CITY OF ALBUQUERQUE

**Re: Aspire Subdivision Unit 1 – 11000 Colobel Ave SW
Erosion and Sediment Control Plan
Engineer's Stamp Date 3/01/2021 (N09E006F)**

ESC-1

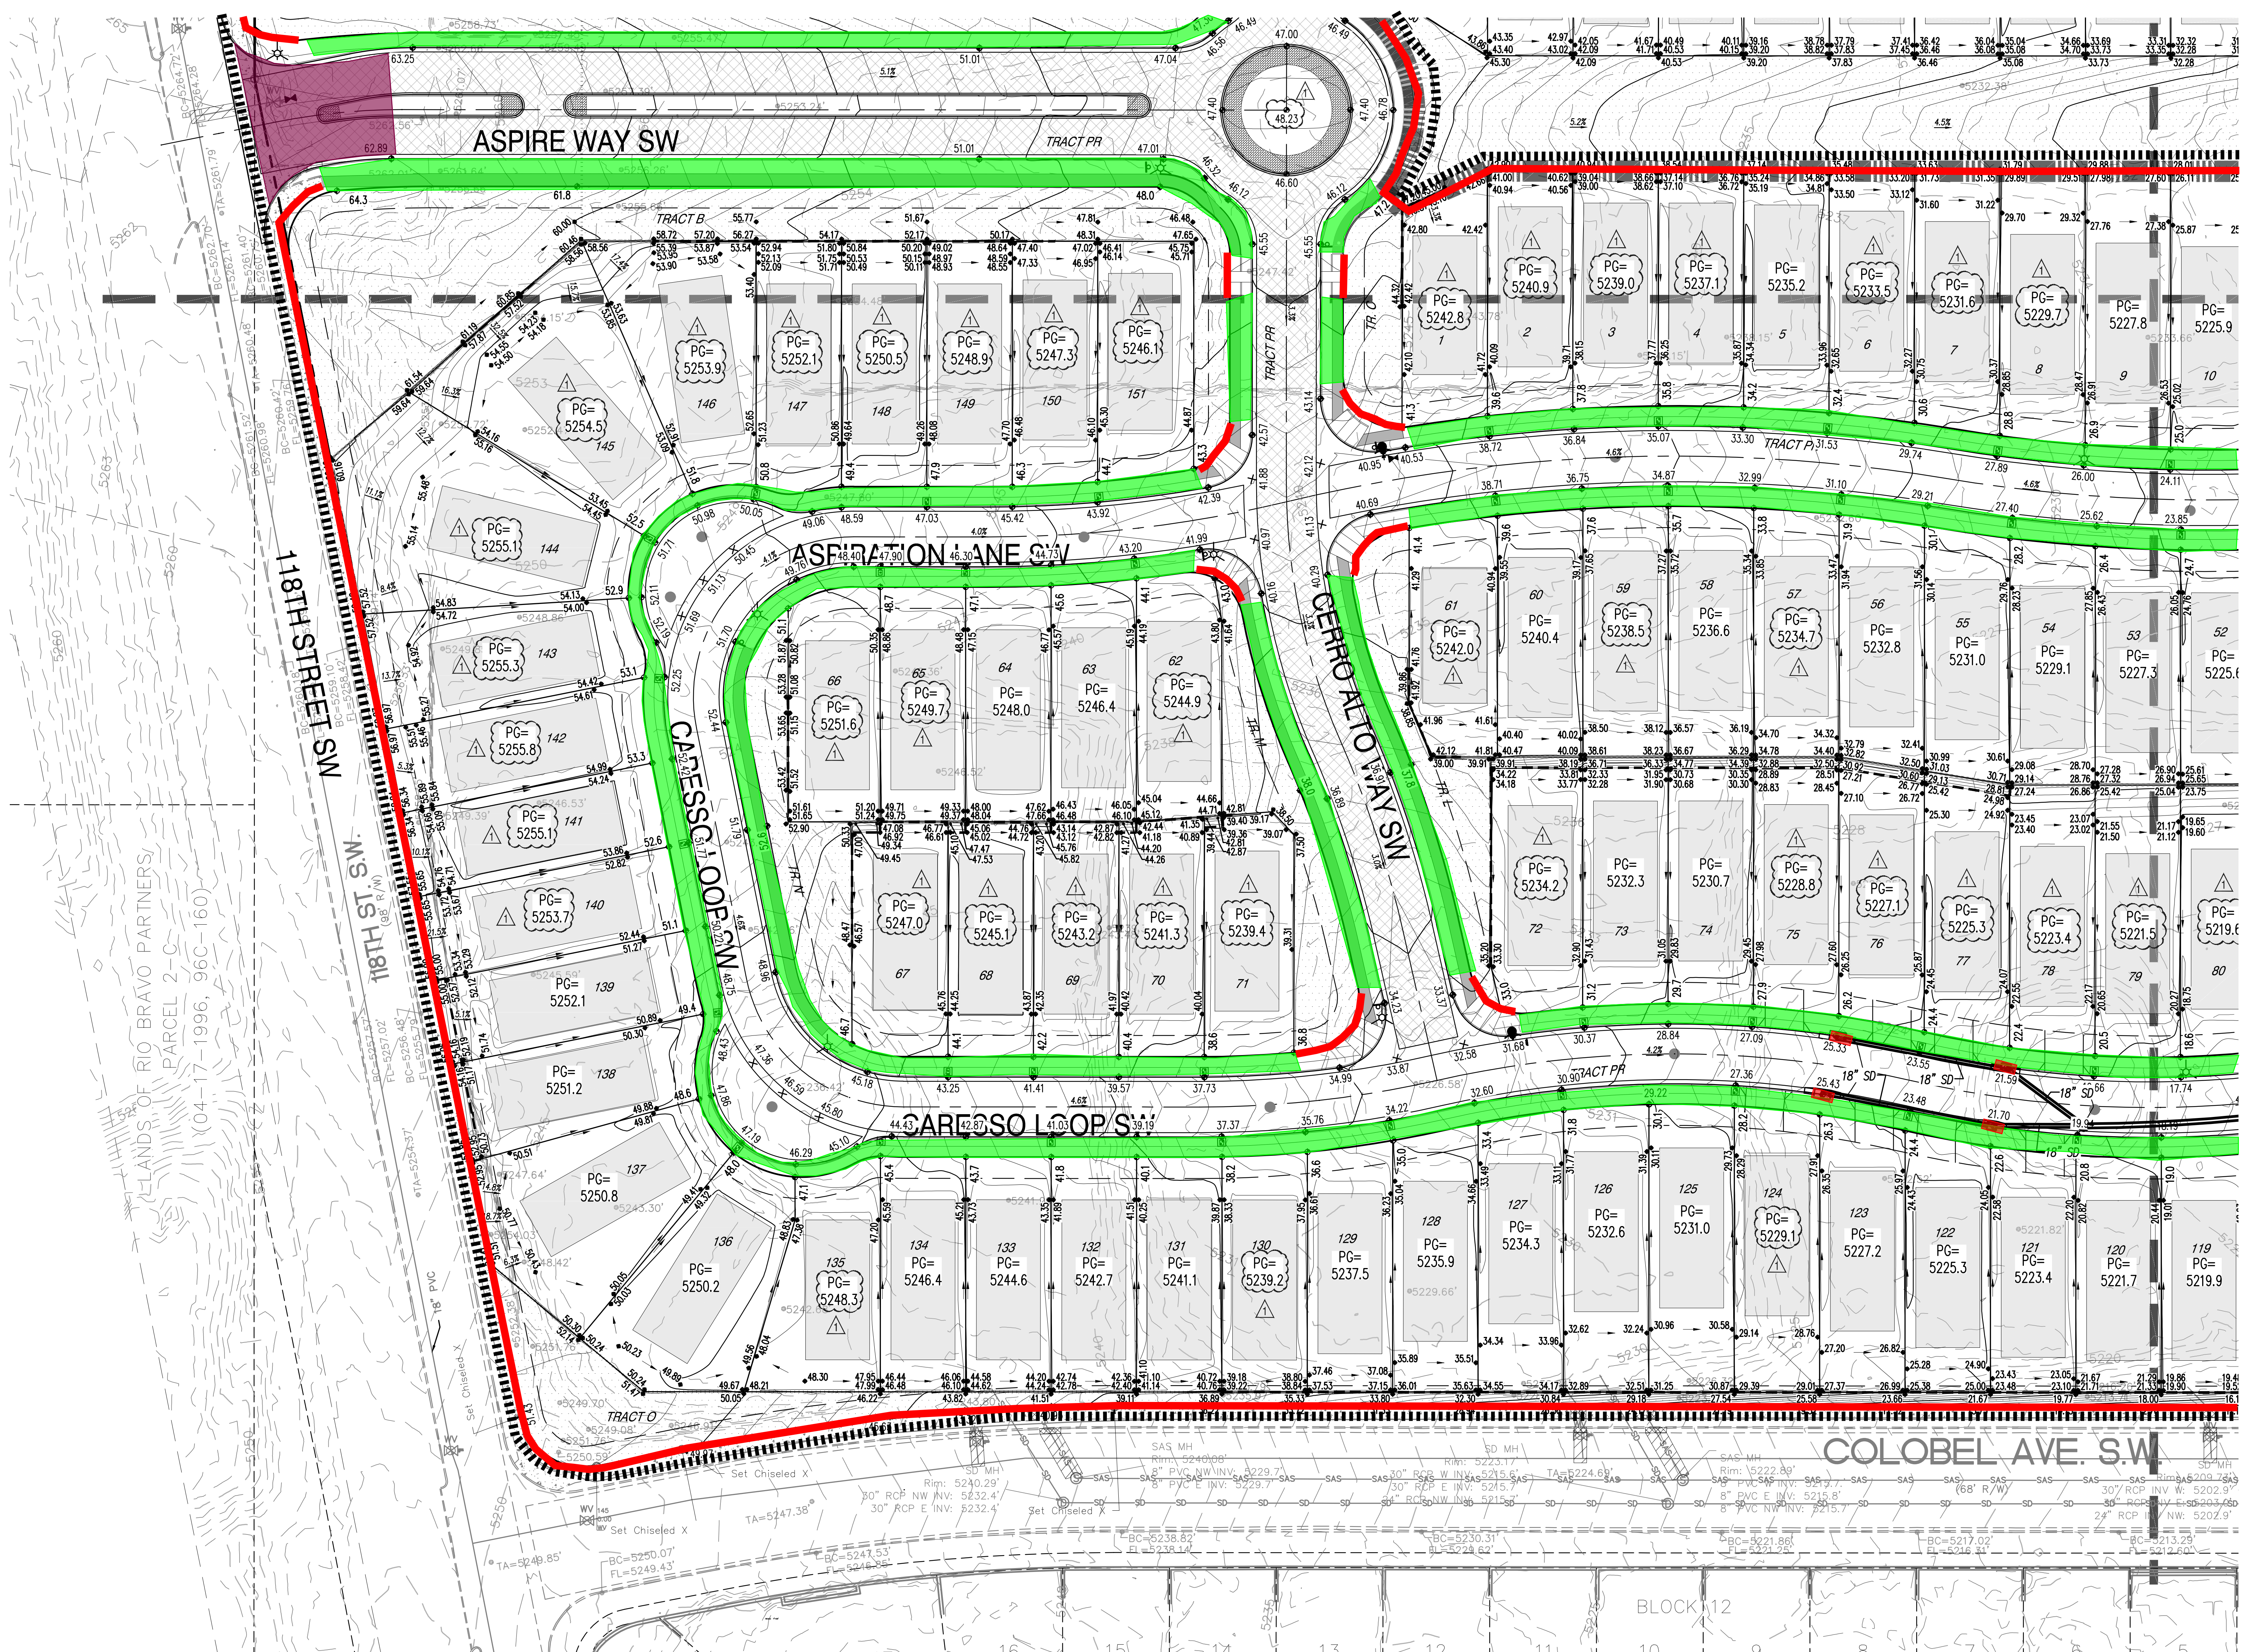
1. The fees for infrastructure must be added to the fee calculations on the info sheet and the fees need to be paid.
2. The limits of disturbance go beyond Unit 1. Most of it is shown on the Interim G&D Plan, but the north road connection to Amole Mesa is missing and should be included. Add sheets as necessary to revise the ESC Plan to show all land disturbance and revise the NOI for this and any subsequent additions to the project within 7 days.

3. Include a schedule on the ESC Plan per CGP 7.2.3.f. Consider presenting 2 phases, 1) infrastructure construction and 2) house construction. The sheets that you already have seem appropriate for the house construction phase.
